From: Charlotte Watkins
Sent: 08 December 2022 14:02
To: Andy Bateson
Cc: Nicholas Wyke
Subject: 22/01144/F- Siemens Healthineers Junction 9 M40. Conditions.

Please find below some initial comments on the draft condition fulfilment documents:

SITE LOGISTICS AND LAYOUT PLAN

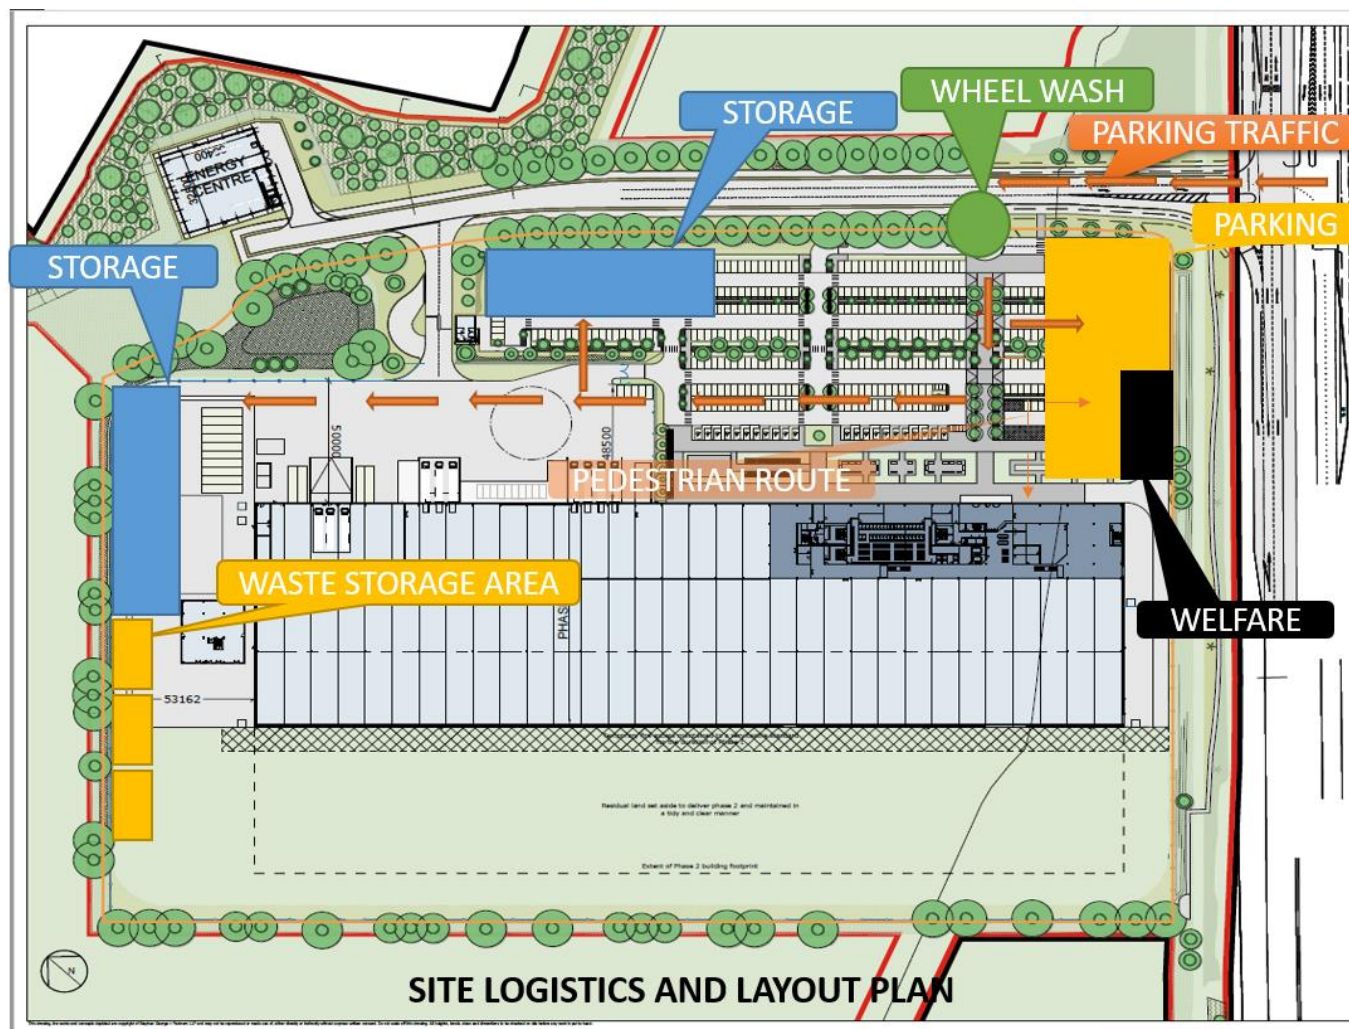
No particular issues. It would be helpful to have a plan of the proposed biodiversity protection zones to be fenced off.

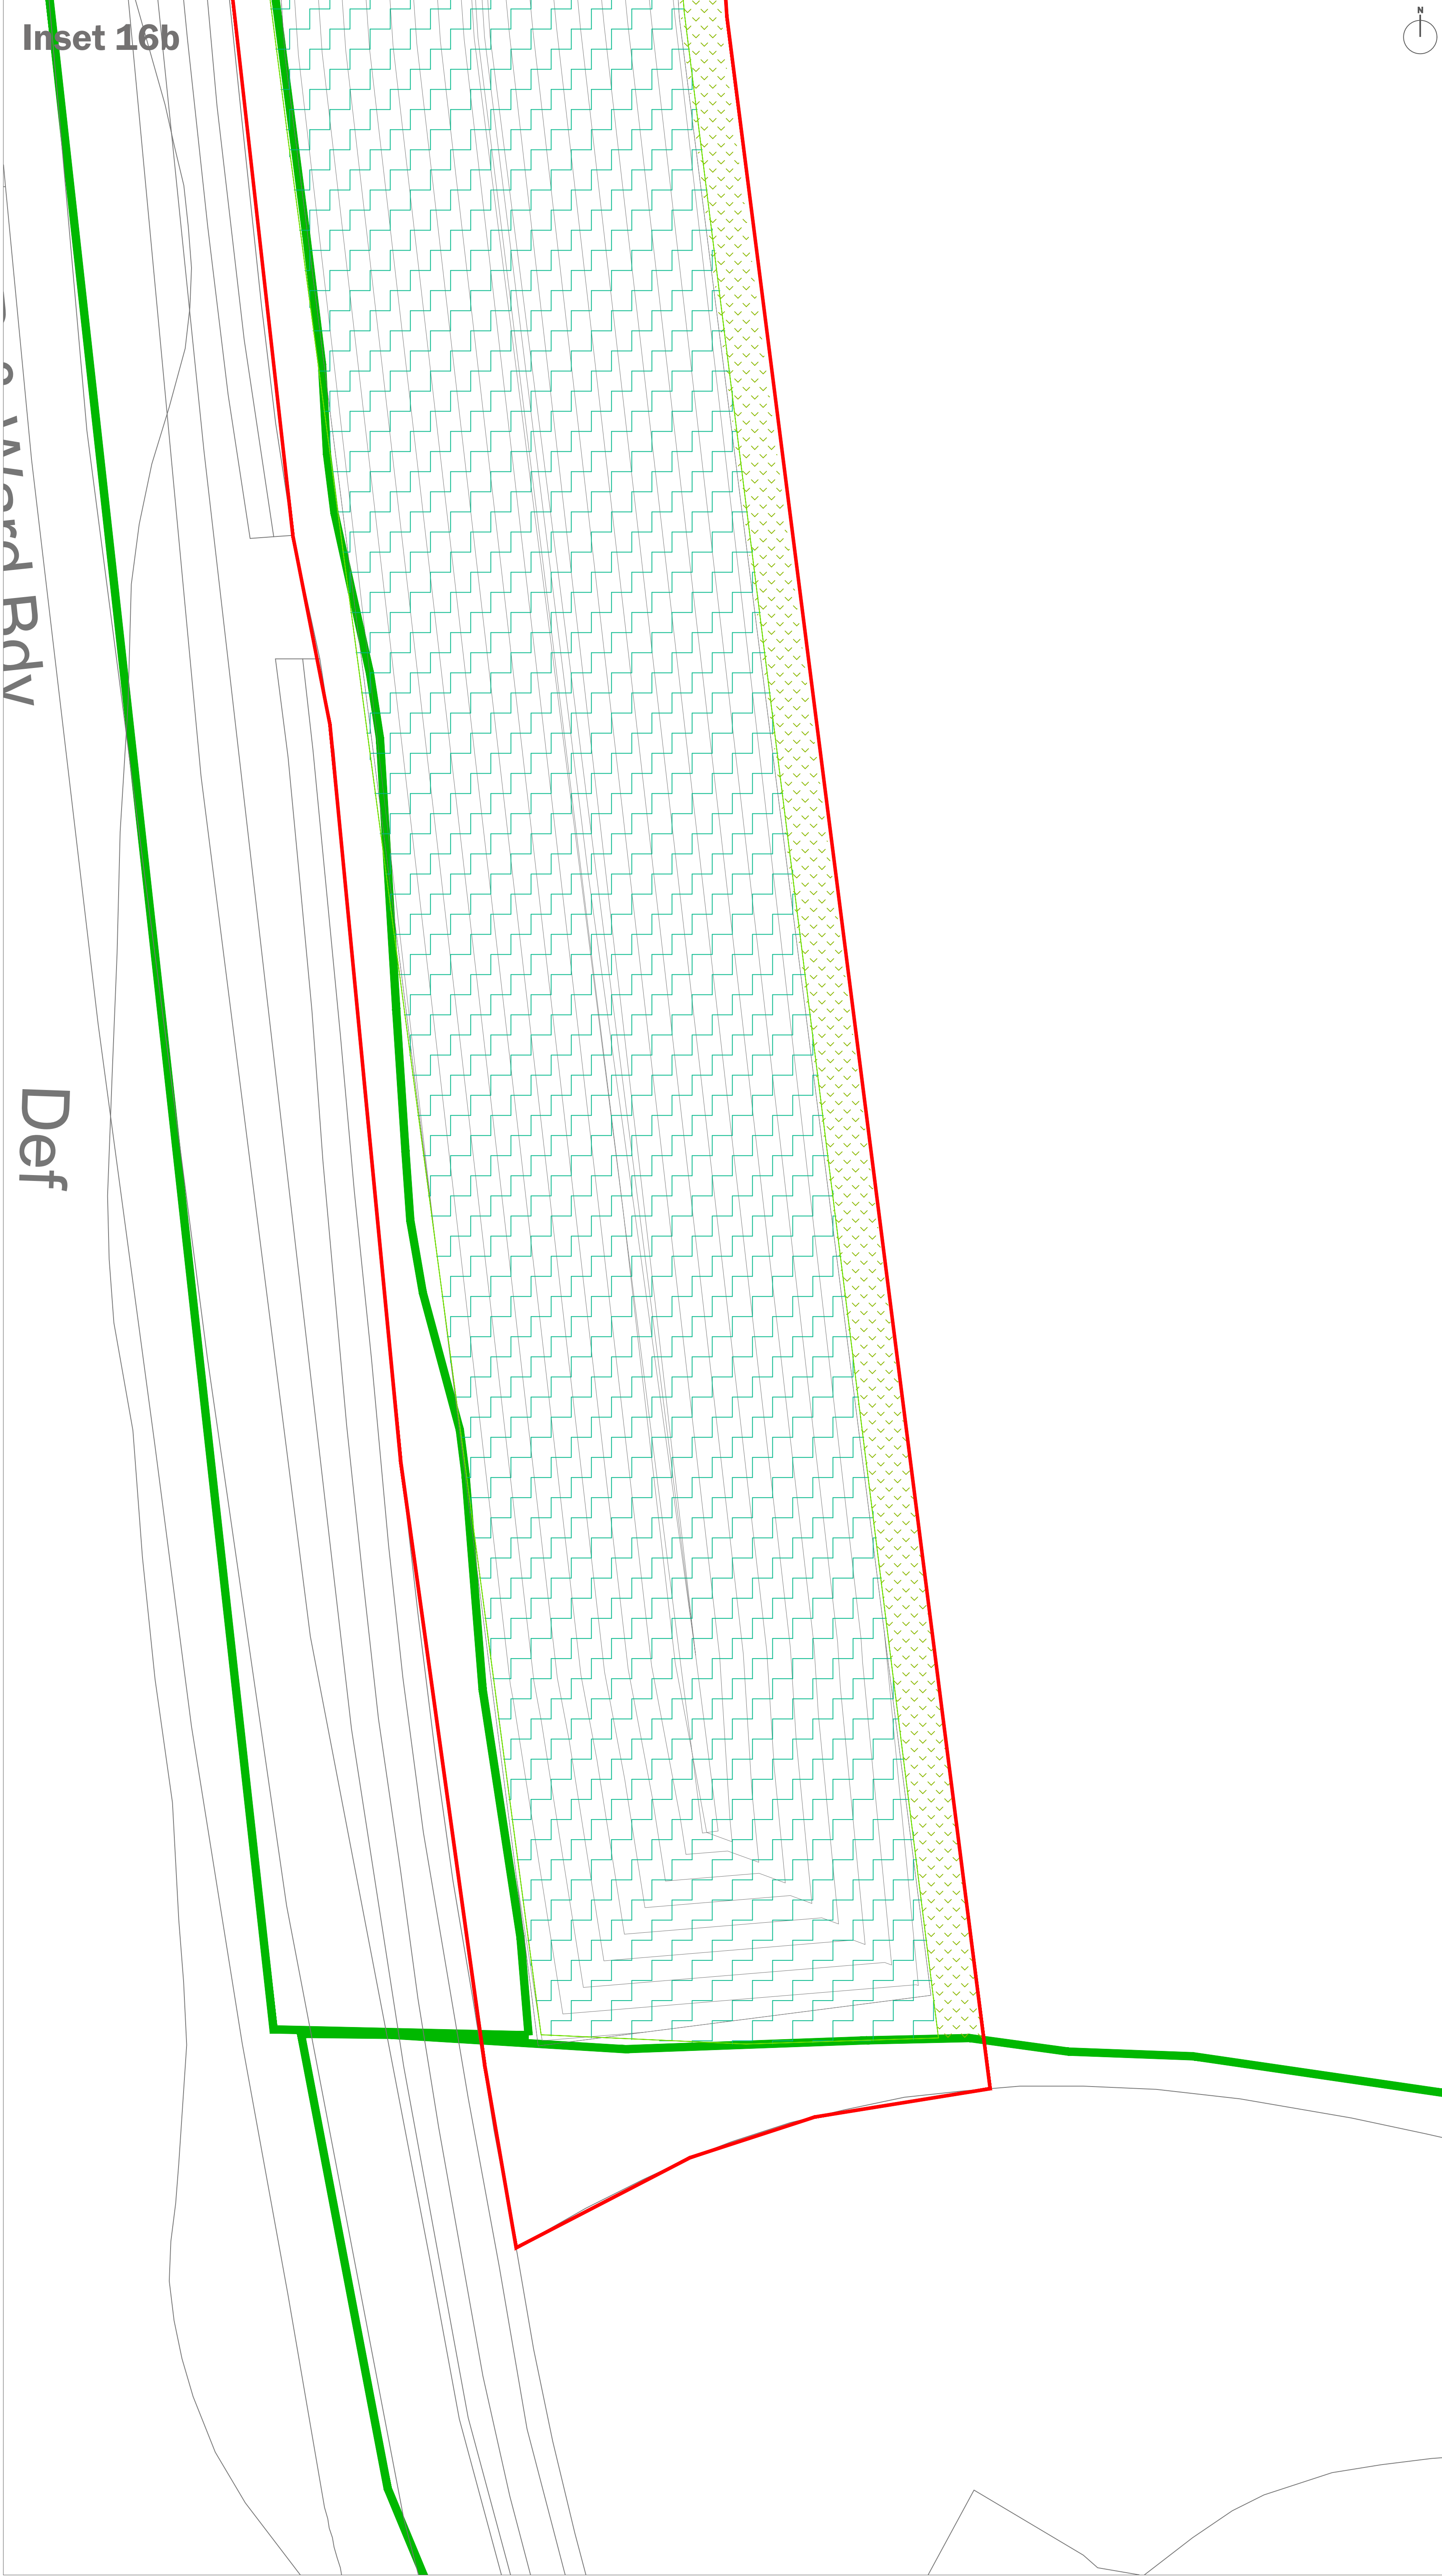
The tree/woodland strip to be created to the North of the woodland seems to be missing from the table EDP 5.1:

Proposed Habitat and Target Condition, with Time to Target Condition for Post-development Habitat Creation.
